WEST SUSSEX COUNTY COUNCIL CONSULTATION

TO:	Arun District Council FAO:David Easton
FROM:	WSCC - Highways Authority
DATE:	16 July 2019
LOCATION:	Land north of Hook Lane, Pagham
SUBJECT:	P/30/19/OUT Outline application with some matters reserved for the construction of up to 300 No. new homes, a care home of up to 80 beds, D1 uses of up to 4,000 sqm including a 2 form entry primary school, the formation of new means of access onto Hook Lane & Pagham Road, new pedestrian & cycle links, laying out of open space, new strategic landscaping, habitat creation, drainage features & associated ground works & infrastructure. This application may affect the setting of a listed building & is a Departure from the Development Plan (resubmission following P/6/17/OUT).
DATE OF SITE VISIT:	N/a
RECOMMENDATION:	No Objection
S106 REQUIREMENTS:	Proposed improvement works to the B2166/Vinnetrow Road roundabout as shown on drawing number 1616/14 or any other such scheme as agreed with WSCC*. These works should be completed by the occupation of the 100th dwelling. Contribution of £114,184 towards improvements to Pagham Road/B2166 Lower Bognor Road junction or any other works that would mitigate the increas

TITLE
**PROPOSED MITIGATION WORKS
- B2166 VINNETROW ROAD**

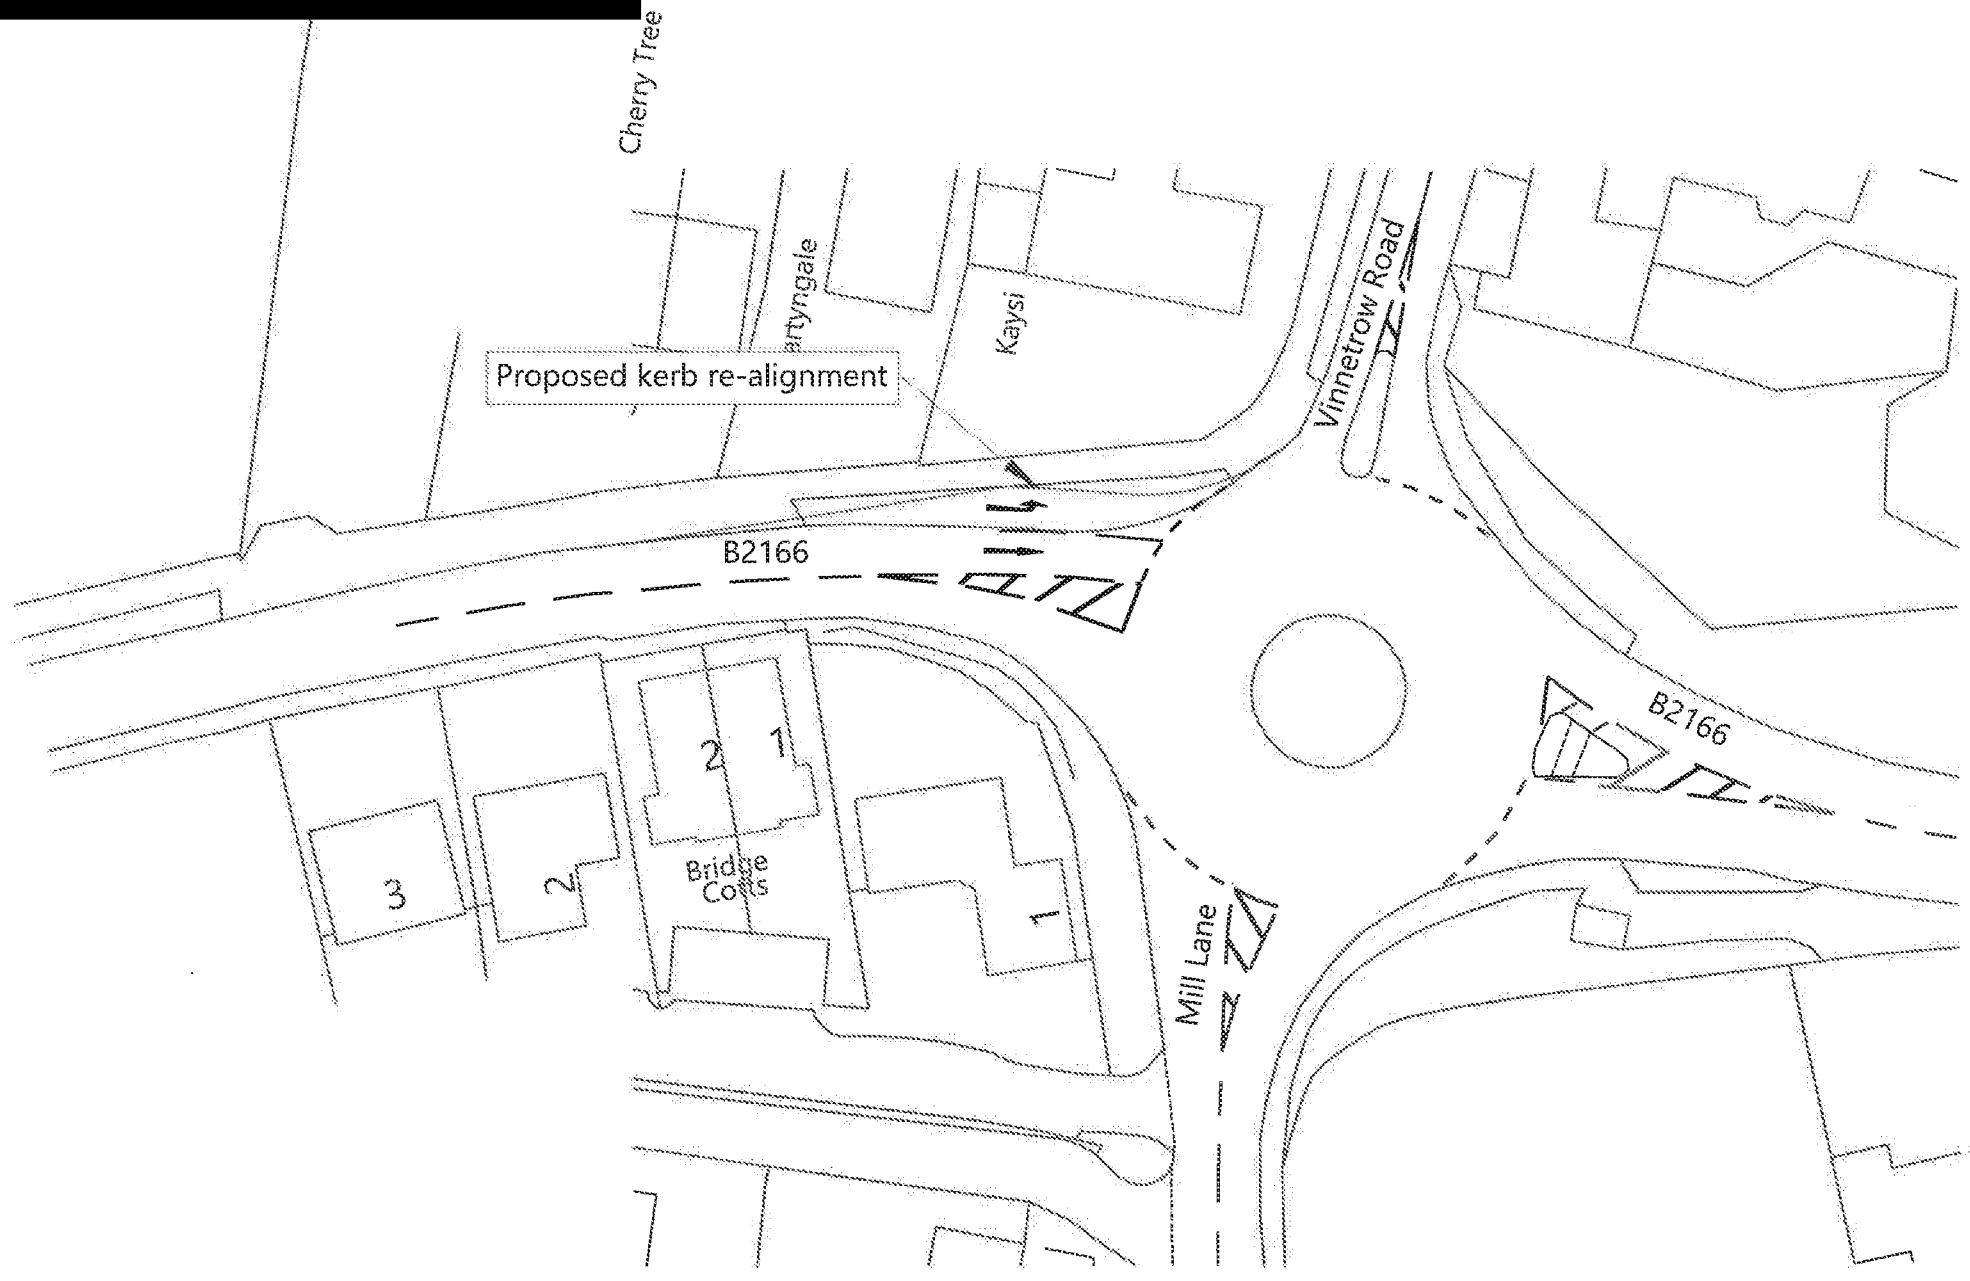
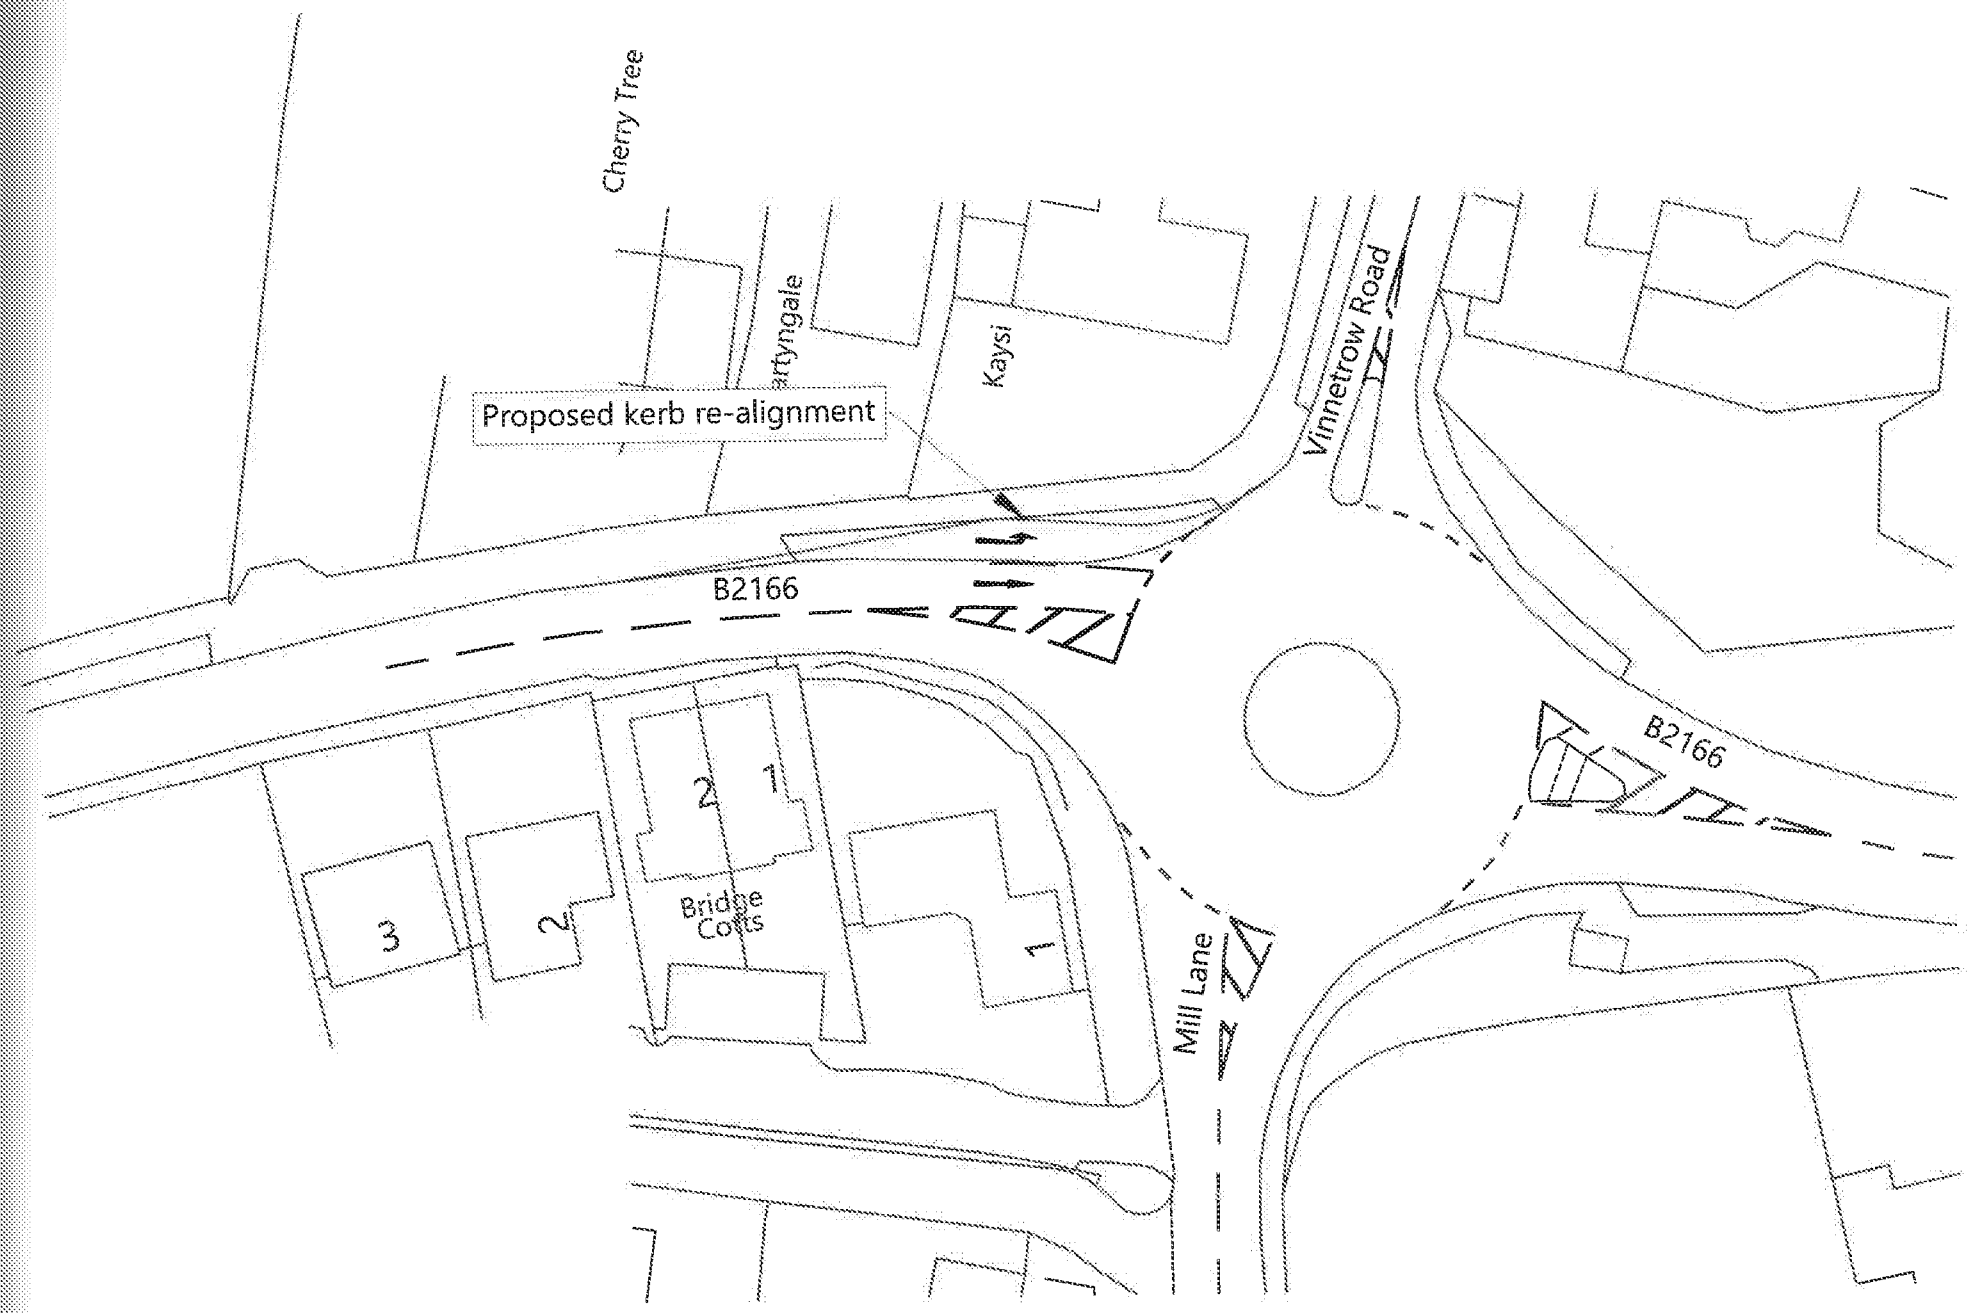
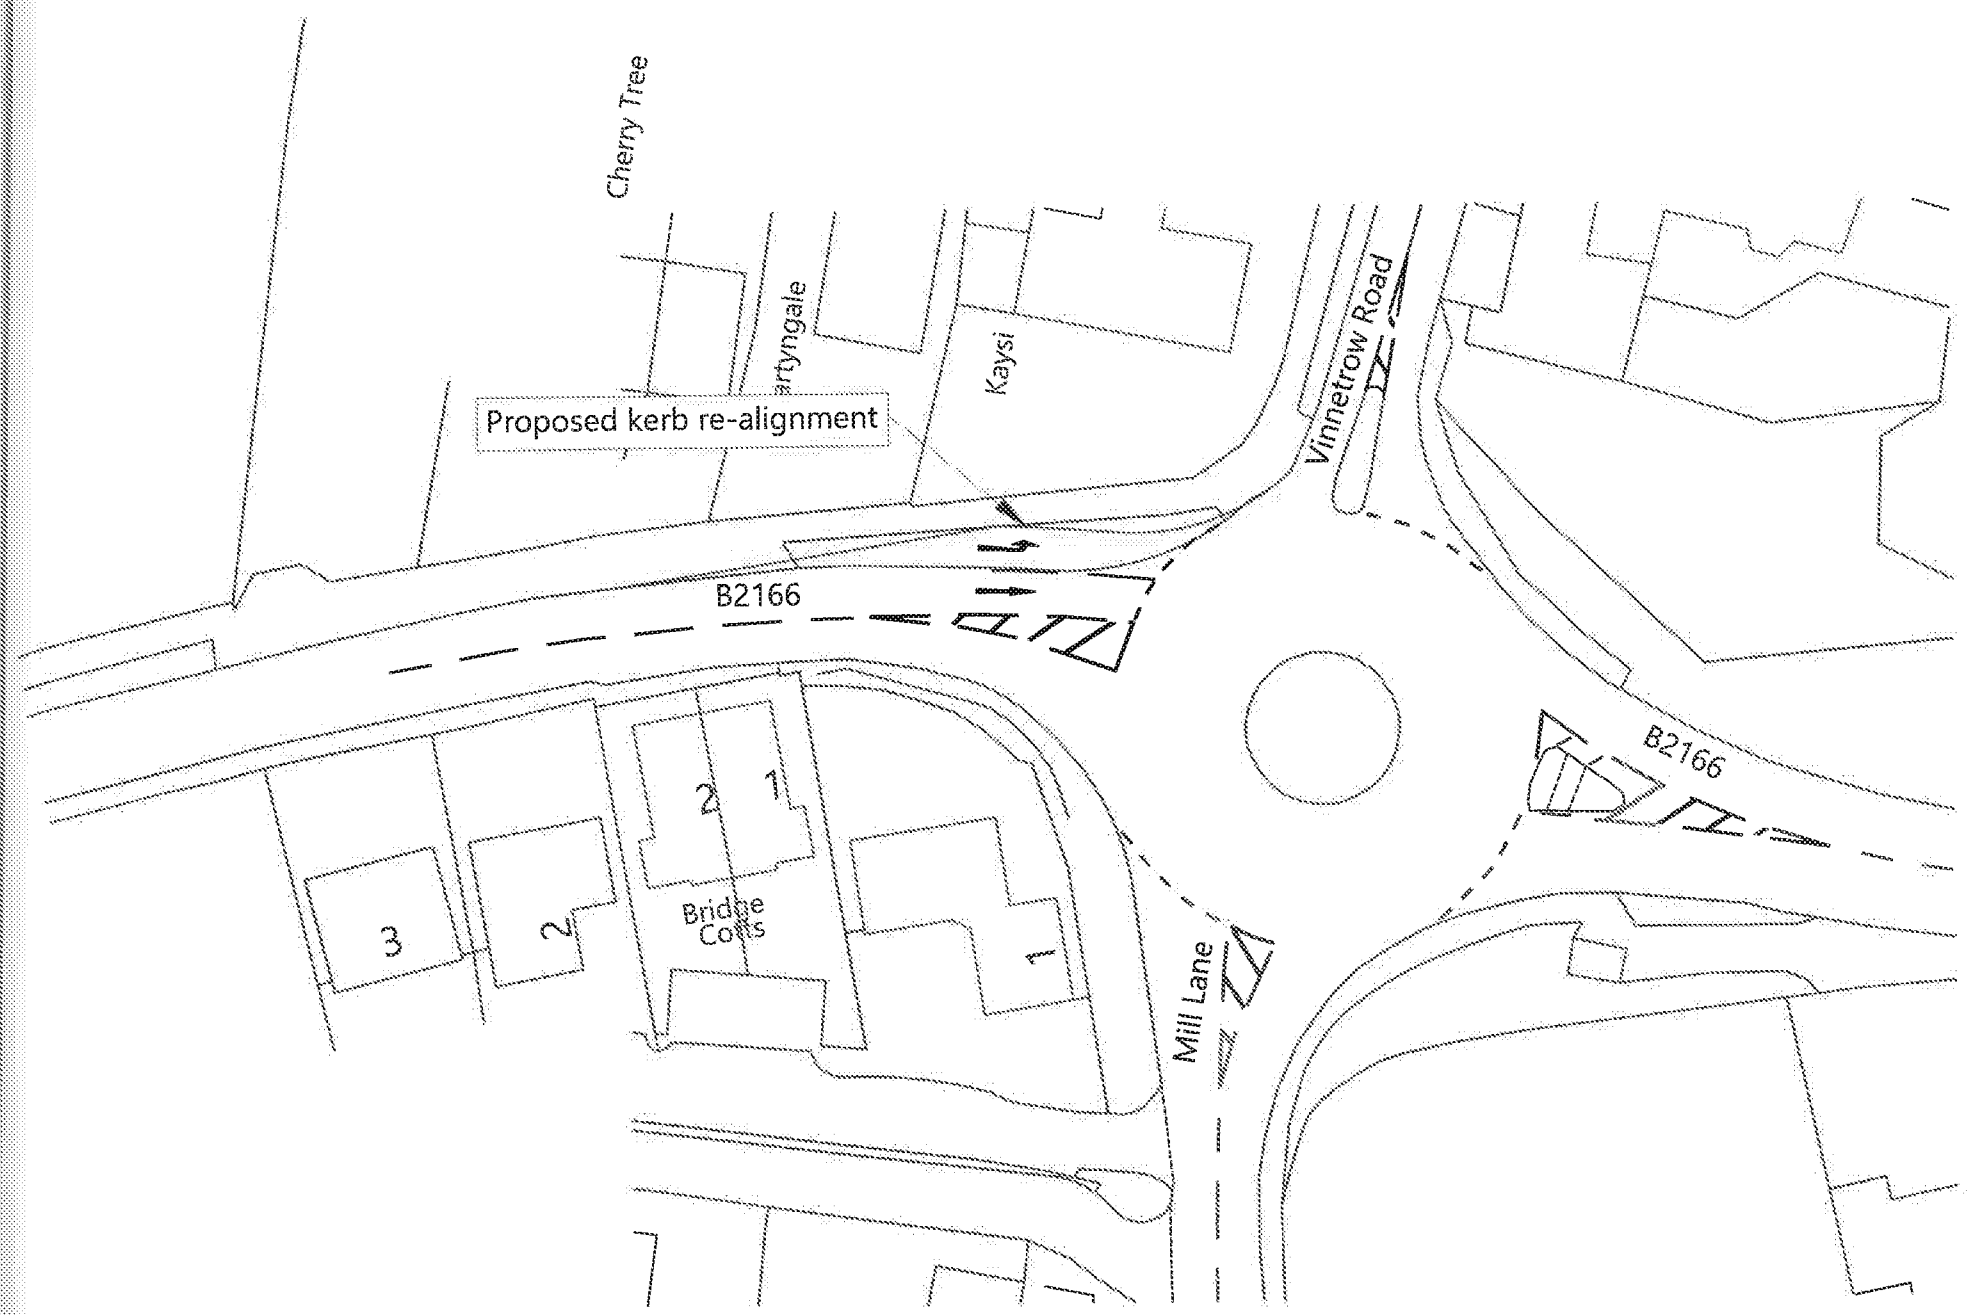
- Proposed improvement works to the B2166/Vinnetrow Road roundabout as shown on drawing number 1616/14 or any other such scheme as agreed with WSCC*. These works should be completed by the occupation of the 100th dwelling.
